From: Matthew C Birch [redacted]
Sent: 19 April 2011 23:11
To: Janice Chapman
Subject: Re: M1/11/ Resubmission

> You may remember a couple of weeks ago you spoke to me about the
> resubmission of 'Retreat' Rose Avenue and the proposed dormers. I
> have since changed the design and tidied up the plans. You will see
> from the attached plans that I have also taken on board your advice in full.

DRAWING SCALE
ELEVATIONS 1/100

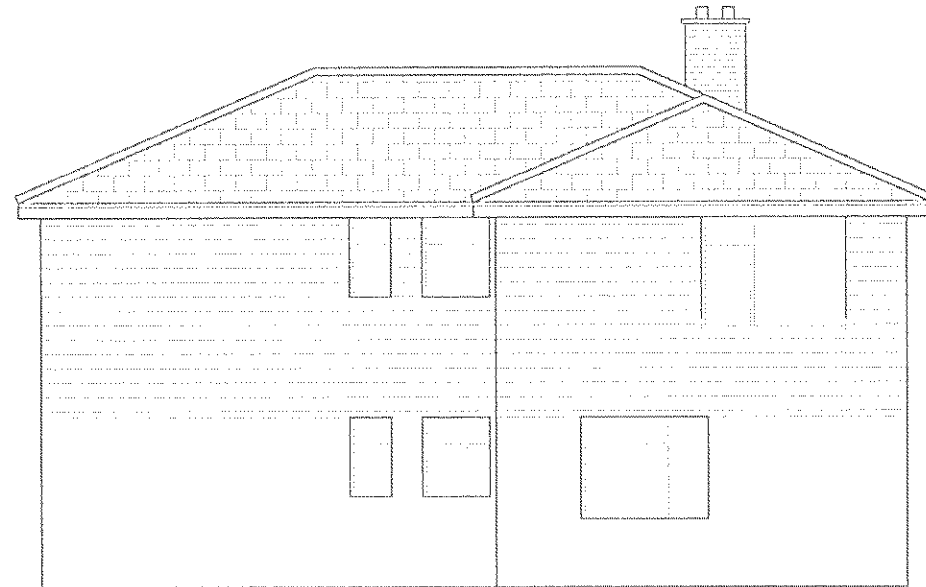
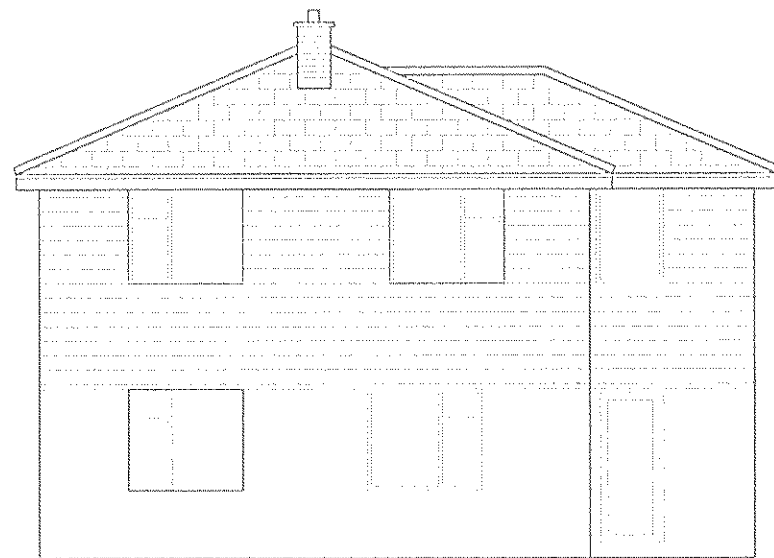
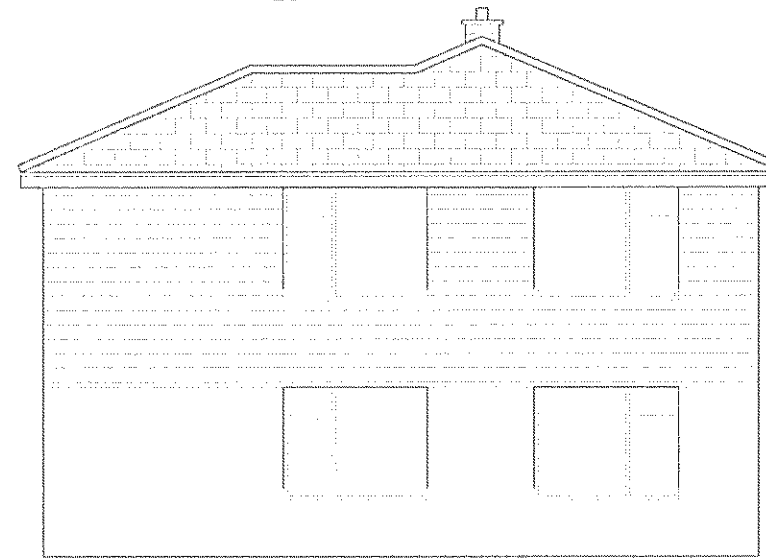
> I am in receipt of your amended elevations. I have discussed the
> drawings with my team leader Mr Parsons and we are both of the opinion
> that the dormers are too large and appear out of character with the
> existing dwelling. It would be more appropriate to have smaller
> dormers and scale down the accommodation at first floor. If you were
> to submit an application it would be likely to be refused as the size
> and scale of the dormers would fail to improve the visual amenities of
> the street scene.

Thank you for your comments although they were not exactly what I wanted to hear. I must have misunderstood your comments on the telephone the other day. I have quickly drawn up another elevation (south) significantly reducing the size of the dormers. I need to keep them that size as the stairs requires the opening above in order to provide sufficient headroom. As this amendment is only to reduce the south facing dormers, no other elevations would be affected.
